MEADOWBROOK PARK PLANNED UNIT DEVELOPMENT (PUD) PLAN

LOCATED IN THE SOUTHEAST 1/4 OF SECTION 8, T14S, R65W, OF THE 6th P.M., EL PASO COUNTY, COLORADO

County File Number: PUDSP20-XXXXX

PROJECT NO.
096956009
SHEET
06 OF 11

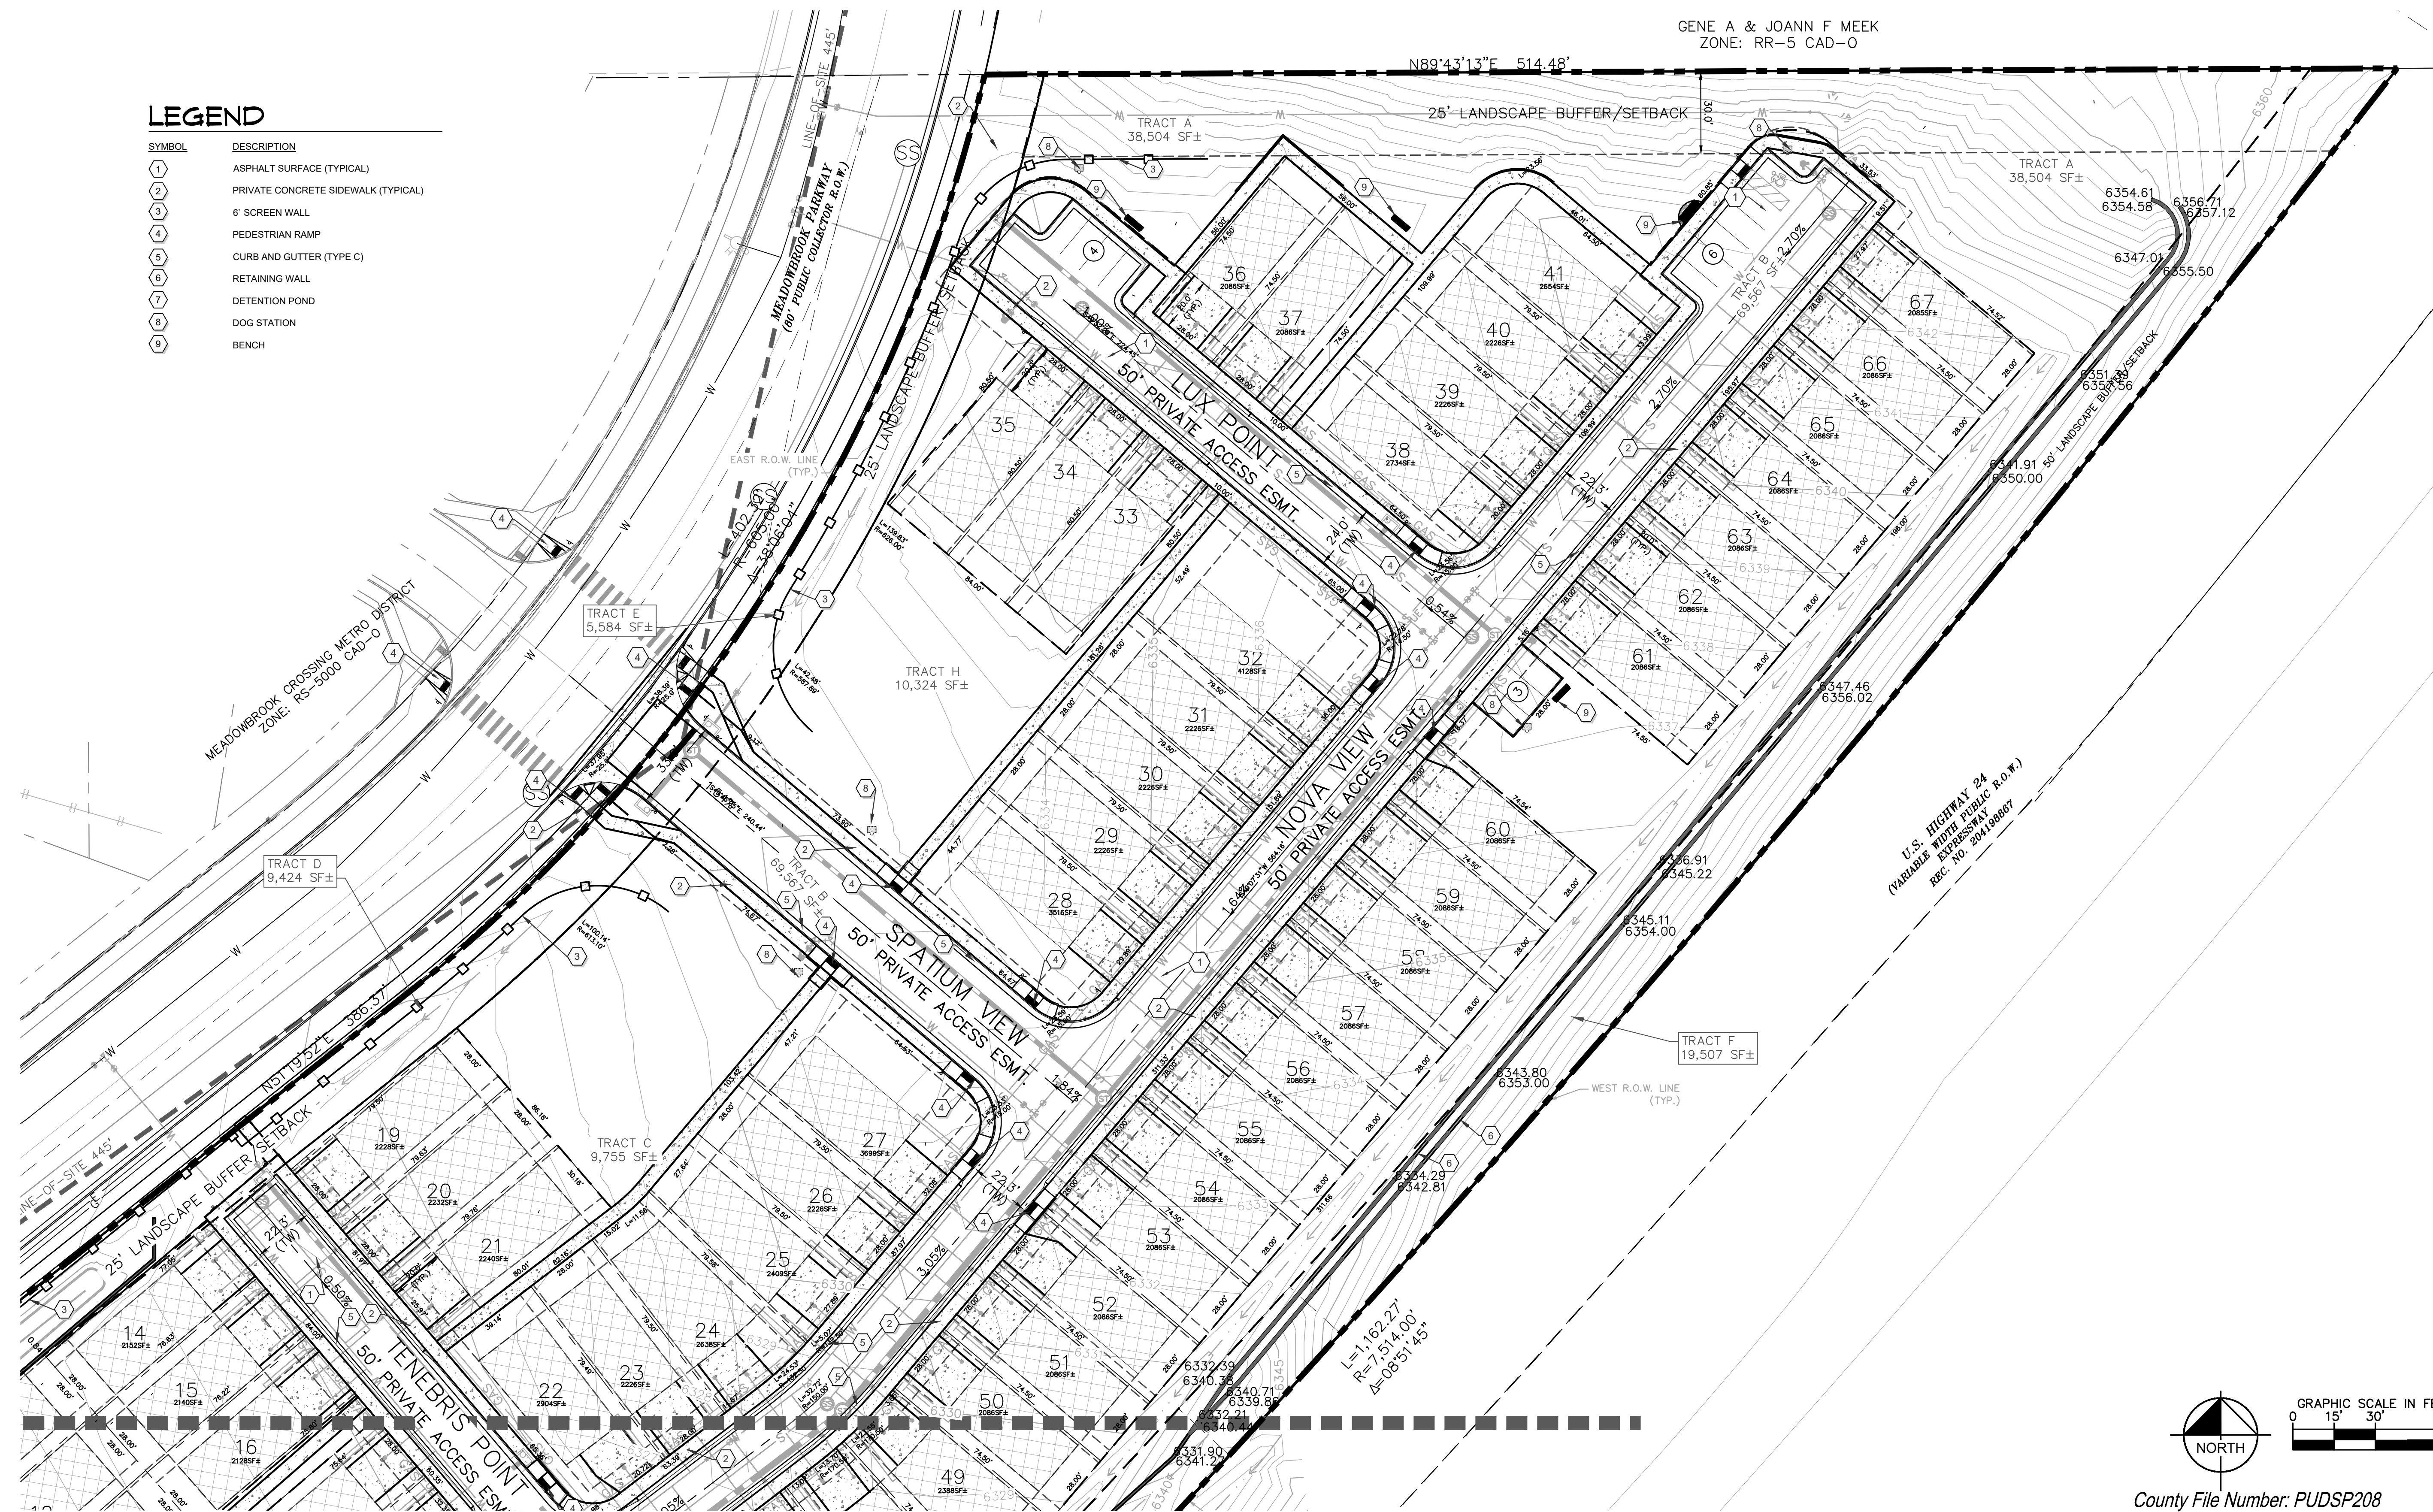
As indicated in the early assistance meeting, the proposed Nova View shall align with existing Preble Dr. Please show Preble Drive on the drawing.

Please show and label the PED ramps. Per ECM 2.5.2.C intersection ramps shall be installed at all intersection corners per County details SD_2-40 and 2-41. PED ramps to cross Meadowbrook will be required as well as ramps at Preble Dr. Also please see comment on sheet 4 regarding the sidewalk along Meadowbrook parkway

Provide the curve data at all intersections.

See comments on previous page regarding PED ramps
